**From:** dc.support@cherwell-dc.gov.uk  
**Sent:** 17 November 2022 10:19  
**To:** DC Support  
**Subject:** New comments for application 22/02647/F

New comments have been received for application 22/02647/F at site address: Unit 6 Oxford Technology Park  
Technology Drive Kidlington  
OX5 1GN

**Address:**  
Kidlington Parish Council, Area Office, Exeter Hall, Oxford Road, Kidlington, OX5 1AB

content: BUILDING 6
PROPOSED SITE LOCATION PLAN

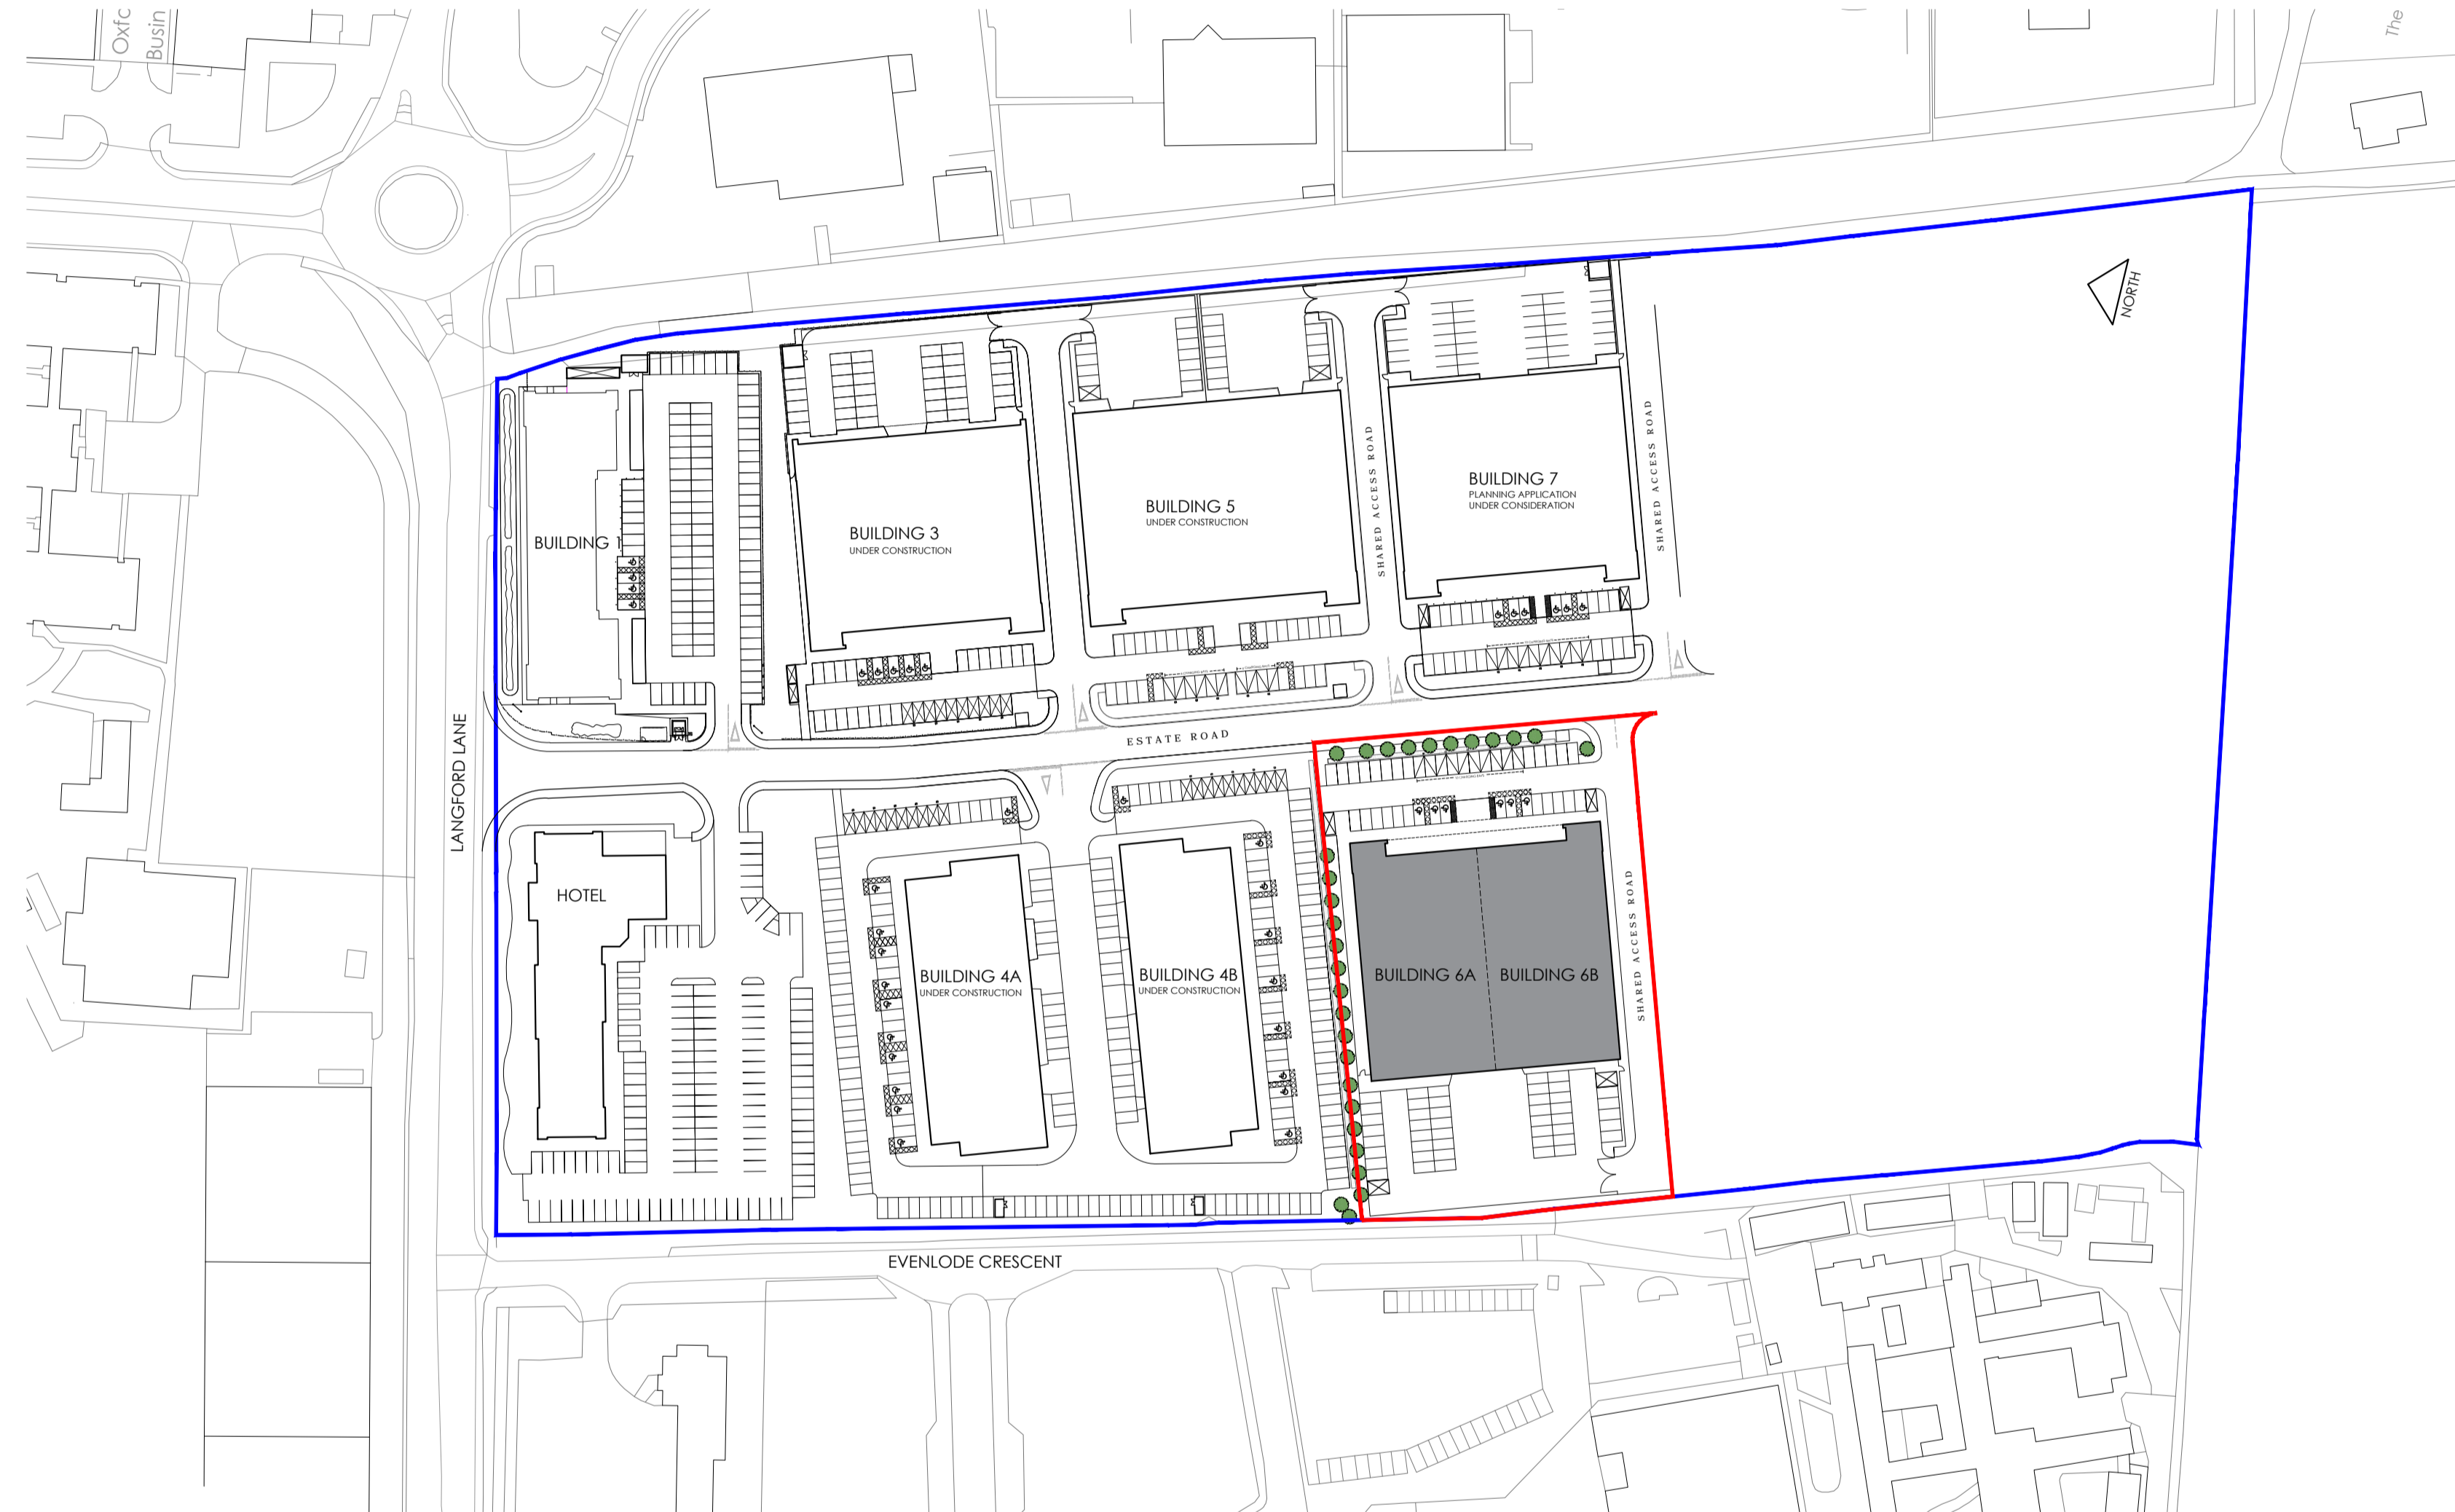
**Comments:**  
Kidlington Parish Council has no objection to the principle of this development; but the submitted plans do not show the of provision of a footpath from the south of the site which had previously been agreed and therefore objects on that ground.
